Project #: 1010058 Application #: 14DRB-70226
14DRB-70225
 Project Name: BOSQUE PLAZA
 Agent: Darren Sewell Architects Phone #:

RE: KEN HURT OFFICE BUILDING
SITE PLAN FOR BUILDING PERMIT
AMENDMENT TO SITE PLAN FOR SUBDIVISION
BOSQUE PLAZA, LOT 5A
ZONE ATLAS PAGE E12

Darren Sowell Architects, llc on behalf of Ken Hurt, requests final sign-off of the amendment of the Site Development Plan for Subdivision and of the Site Development Plan for Building Permit for Lot 5A in Bosque Plaza.

The project will include a new office building for Ken Hurt on Lot 5A, Bosque Plaza, as shown on the Site Plan for Building Permit. The amendment request removes a 12 foot wide pedestrian/vehicle connection from Lot 5A.

LANDSCAPE PLAN

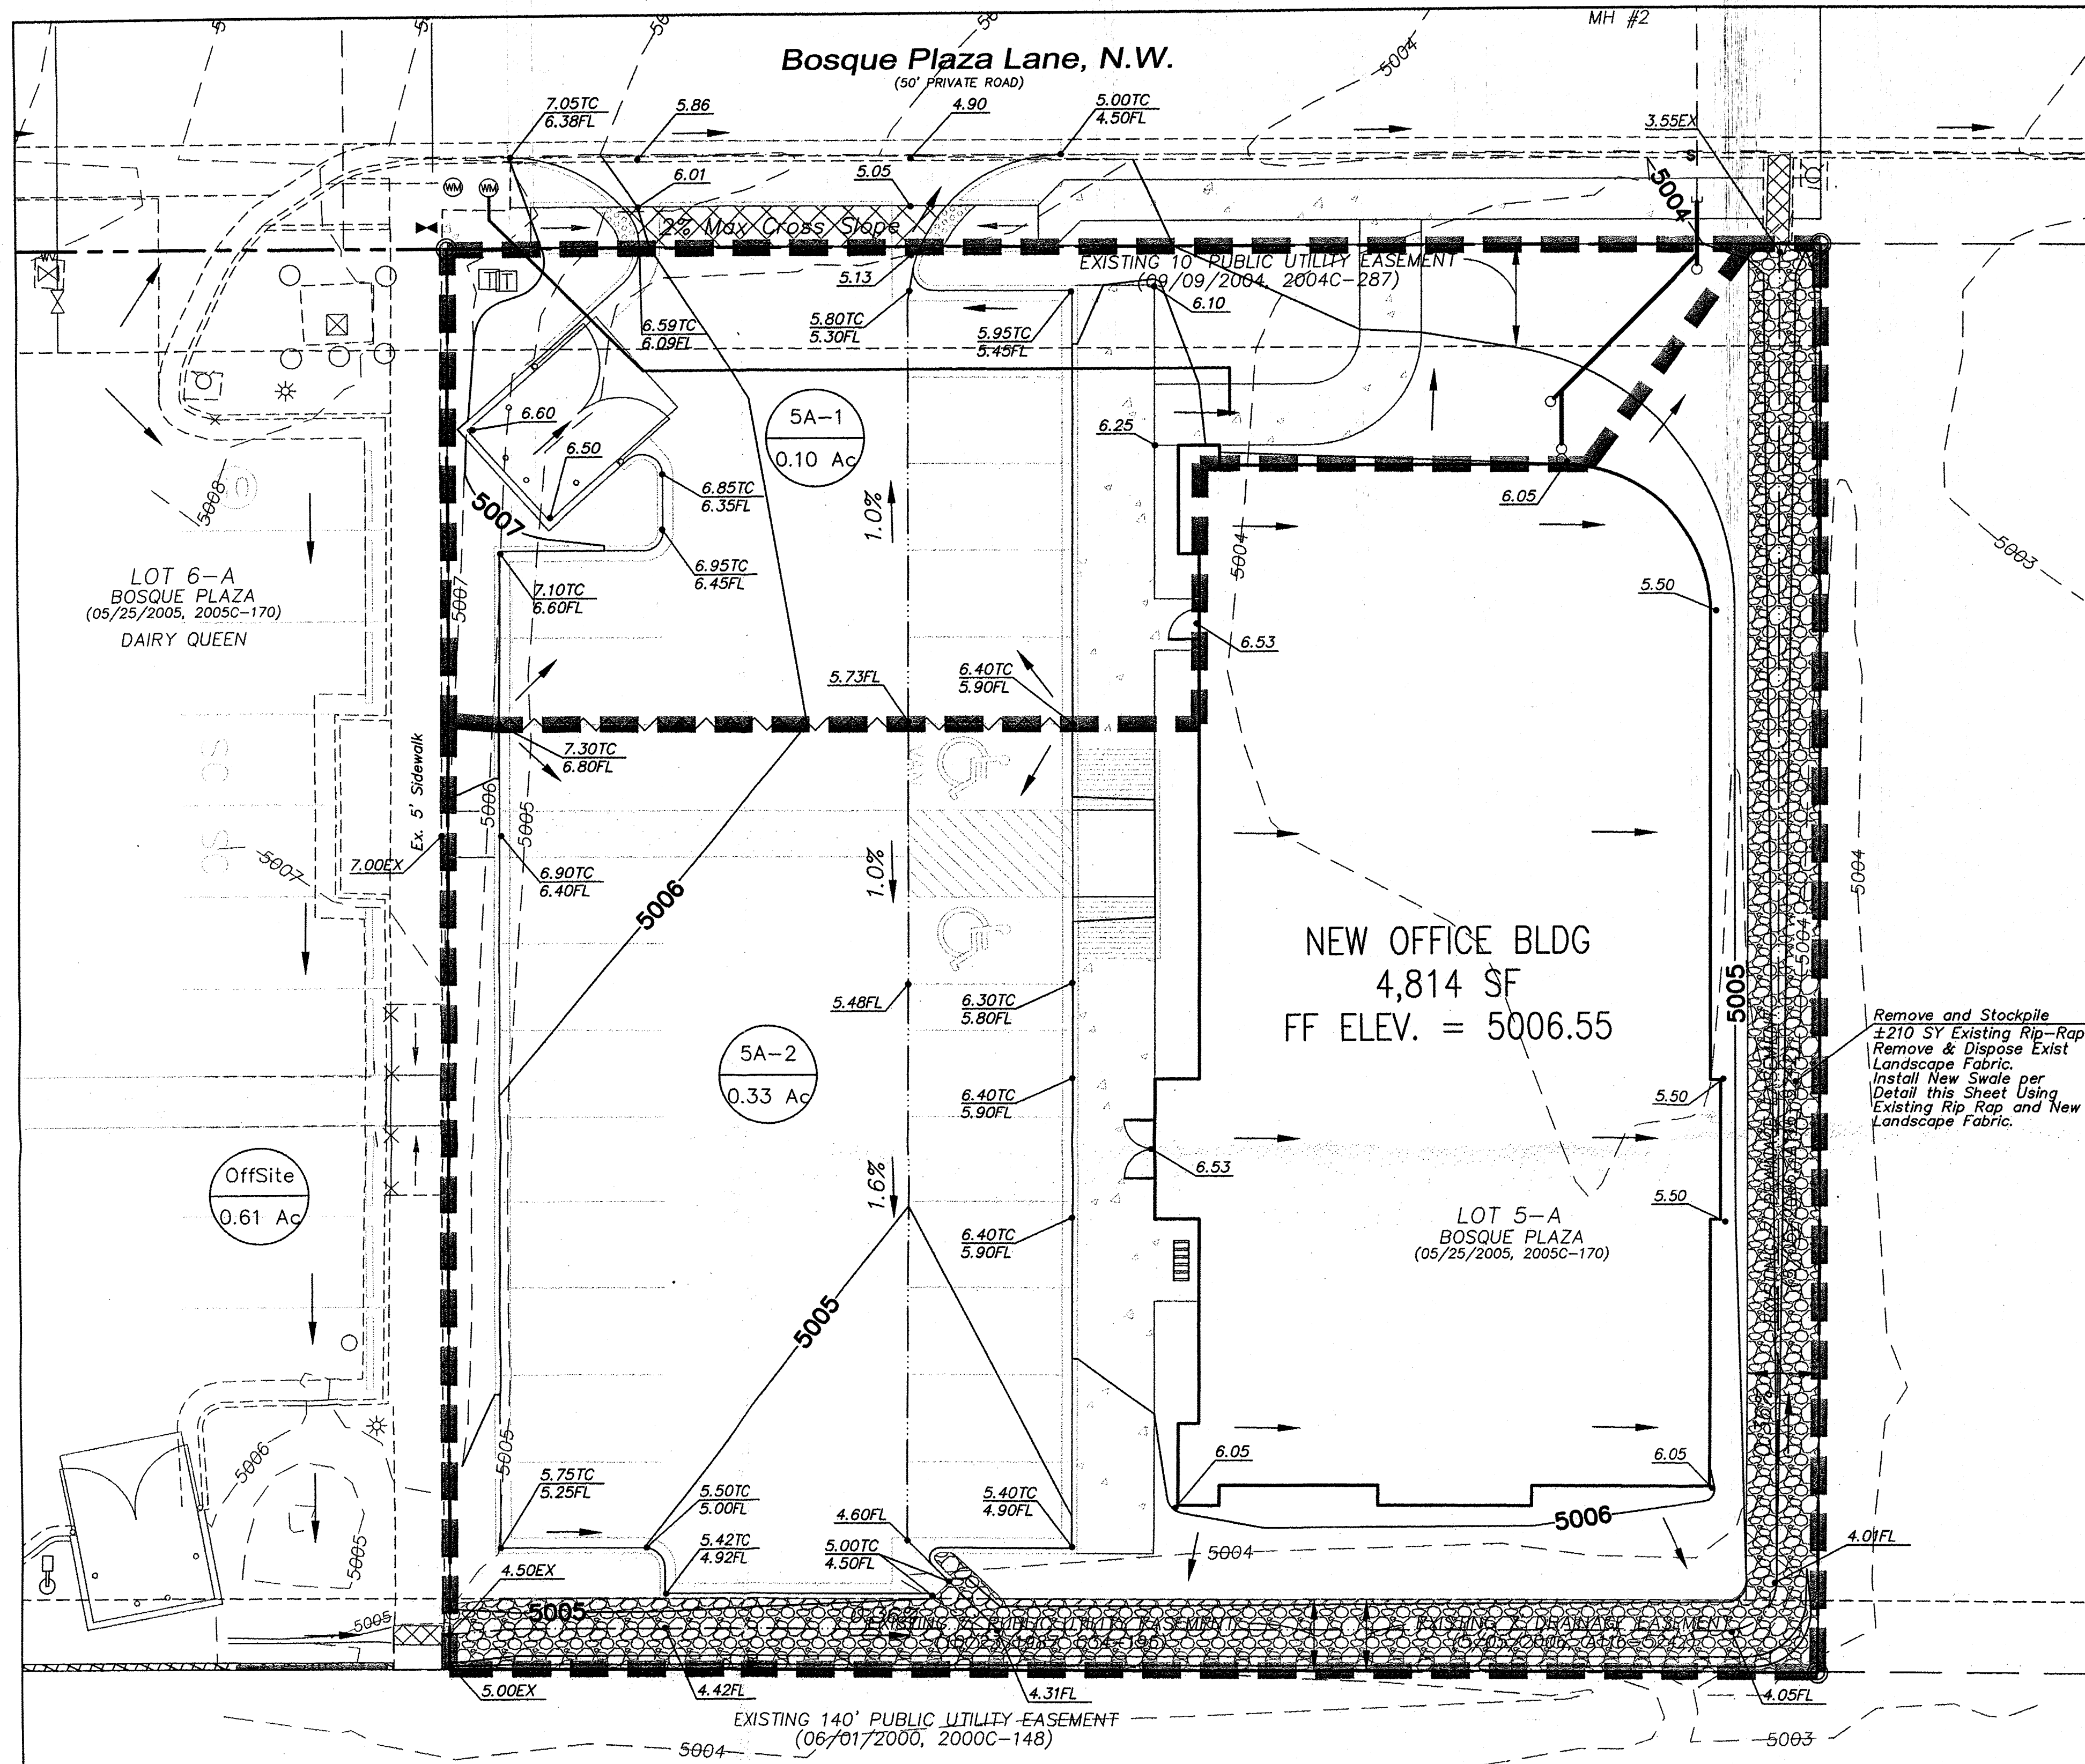
3. The note on the Landscaping plan that states "final landscaping layout and design to be determined upon receipt of final grading plan" must be removed before DRB submittal.

- b. Ground-mounted equipment screening will be designing to allow for access to utility facilities. All screening and vegetation surrounding ground-mounted transformers and utility pads are to allow 10 feet of clearance in front of the equipment door and 5-6 feet of clearance on the remaining three sides for safe operation, maintenance and

This note has been removed.

A note has been added on the landscape sheet L1.
